Proposed first floor rear extension and detached single garage / car port (Resubmission of WA/101/18/HH). This application affects the character and appearance of Walberton Village Conservation Area.

Holly Tree Cottage The Street Walberton

Thank you for your internet representation made on 3rd June 2019 which has been recorded as '**an objection**' with the comments as follows:

CLIENT	Mr & Mrs J Waights	SCALE	1:100 @ A3
SITE	Holly Tree Cottage, The Street, Walberton	STATUS	PL / LBC
PROJECT	Proposed First Floor Extension	AUTHOR	AH
DRAWING	002 Proposed Garage & Roof Plans	DATE	23 04 19

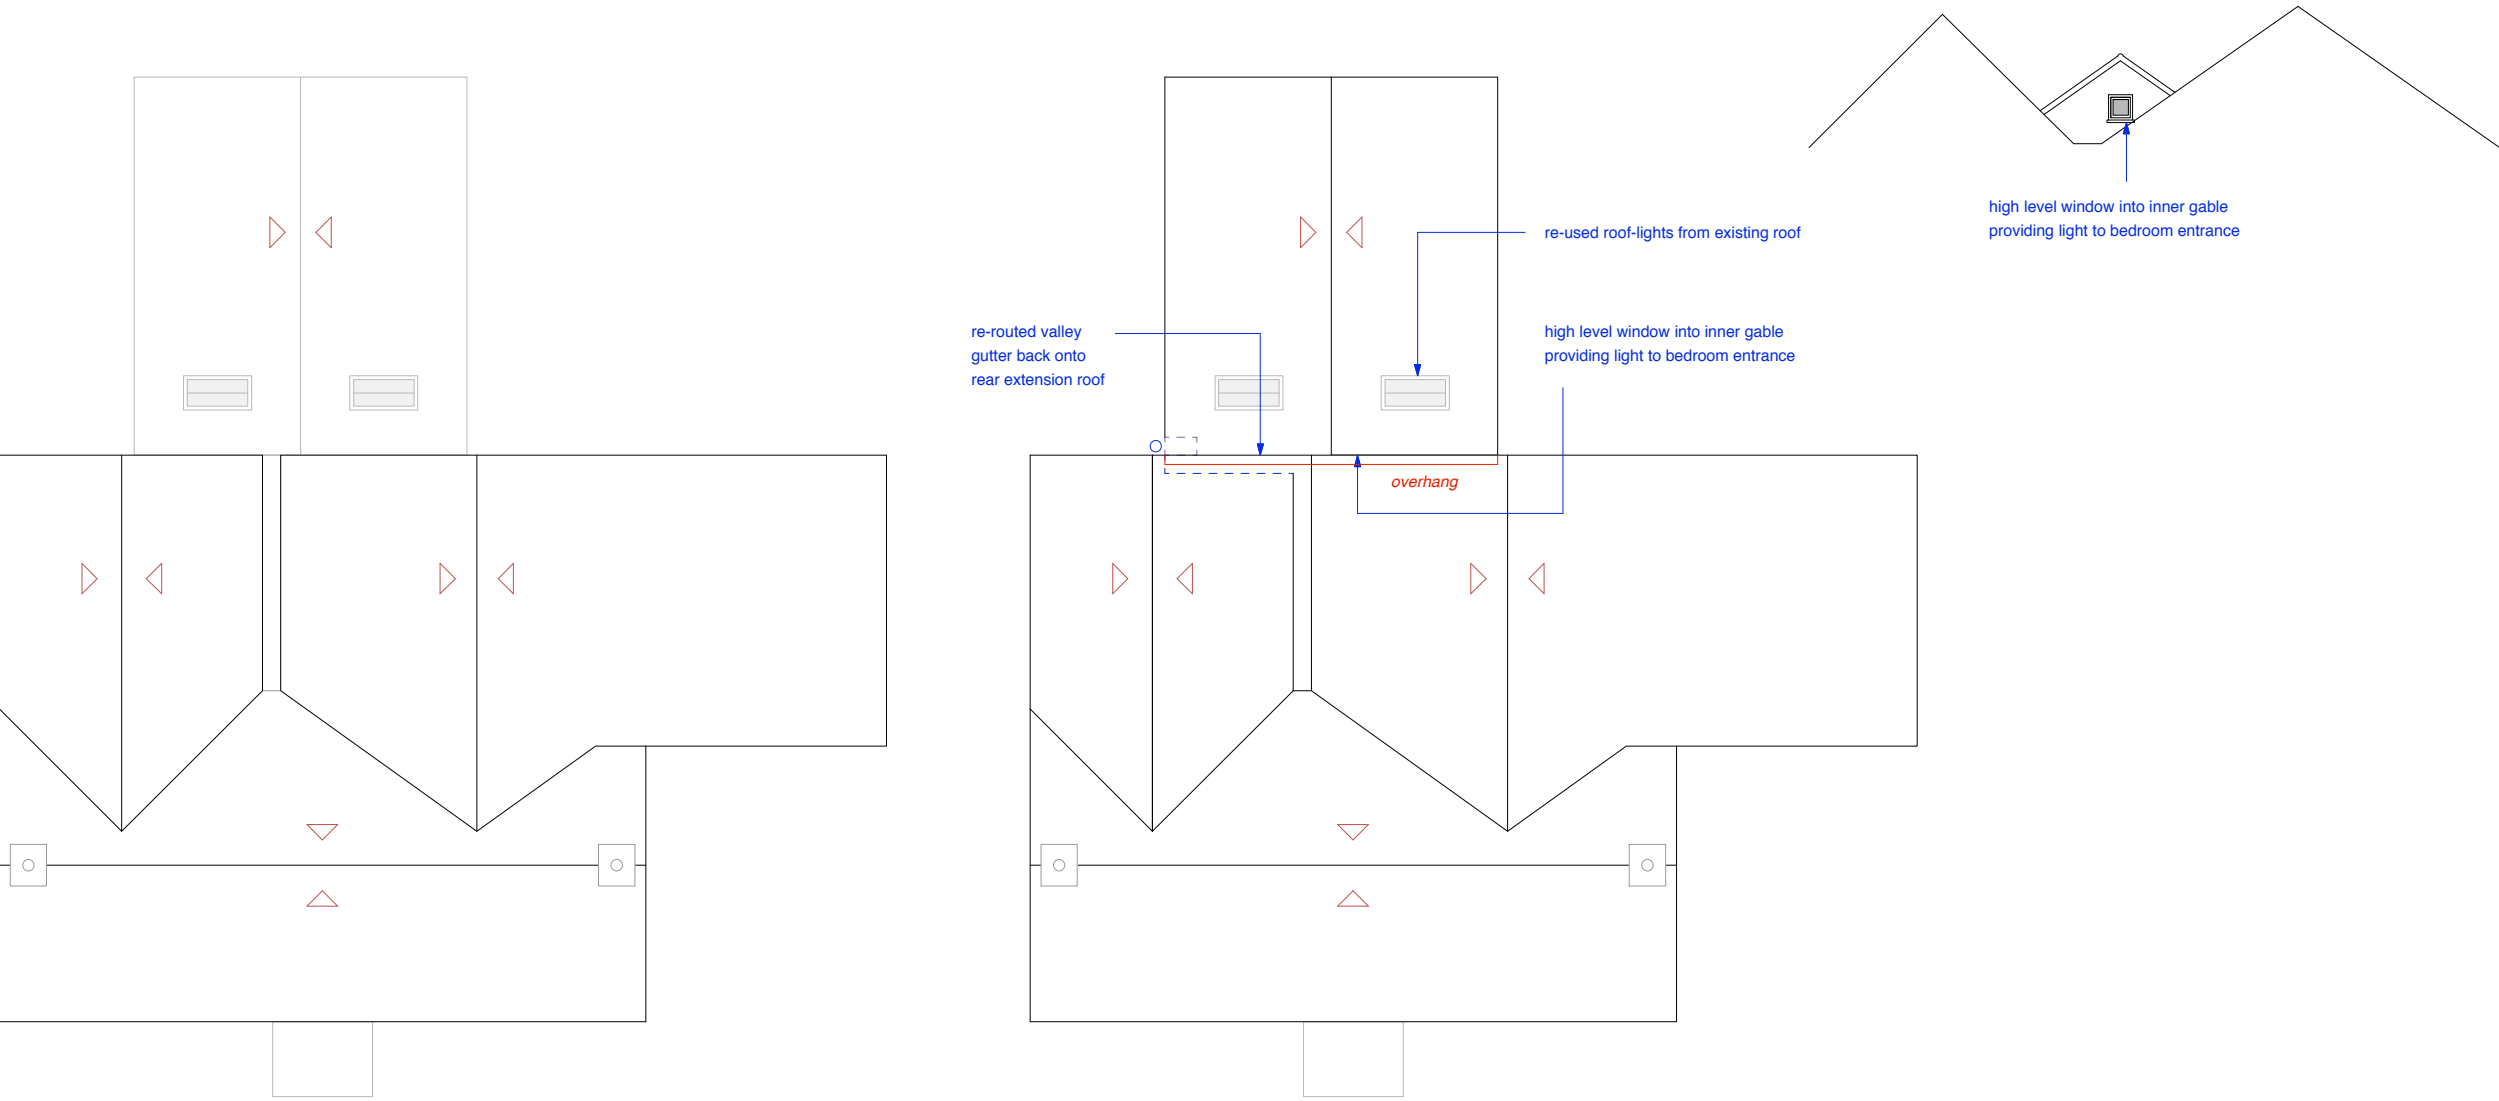
The proposal in its current form would harm the listed building and the Conservation Area. The proposed car port would detract from the setting of the listed building which is of simple form. This form is part of its significance and requires space forward of it in order to preserve its setting. This proposal and conflicts with NPPF 2018 Paragraph 192 (heritage assets - includes Conservation Areas), Paragraph 127 (design quality) and Arun District Local Plan 2018 Policy HER DM3 (Conservation Areas), Policy HER SP1 and Policies DSP1 and DDM1 (design quality)
